From: Fiona Fitzgerald <Fiona.Fitzgerald@arun.gov.uk>
Sent: 24 September 2019 10:22
To: Planning.Responses <Planning.Responses@arun.gov.uk>
Cc: Raymond Cole <Raymond.Cole@arun.gov.uk>
Subject: WA/48/19/RES

Environmental Health has no objection in principle to this application. However, please could you ask the application to provide answers to the following questions:

Local Shop

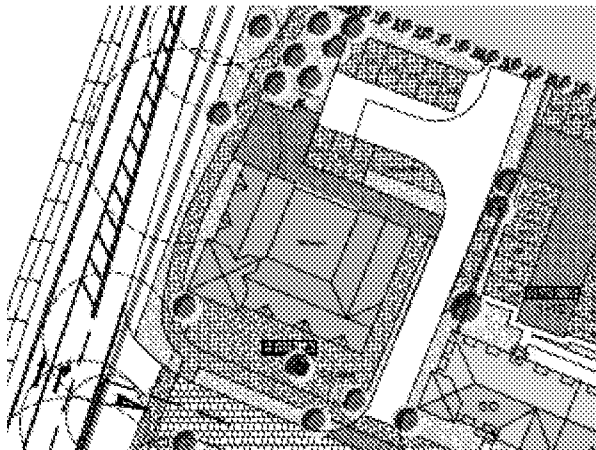
- a. There appears to be no provision for bins for the A1-3 retail units. Please could the applicant provide further information on the commercial waste (e.g. location on bin store etc).
- b. In relation to the D1/D2 use, I have concerns relating to the close proximity of this building to the current residential dwellings. There appears to be no consideration of the potential impact of noise or lighting on the local residents. I would welcome details of how the applicant intends to mitigate any potential future issues regarding this, or indeed whether this is a suitable location for this type of premises.
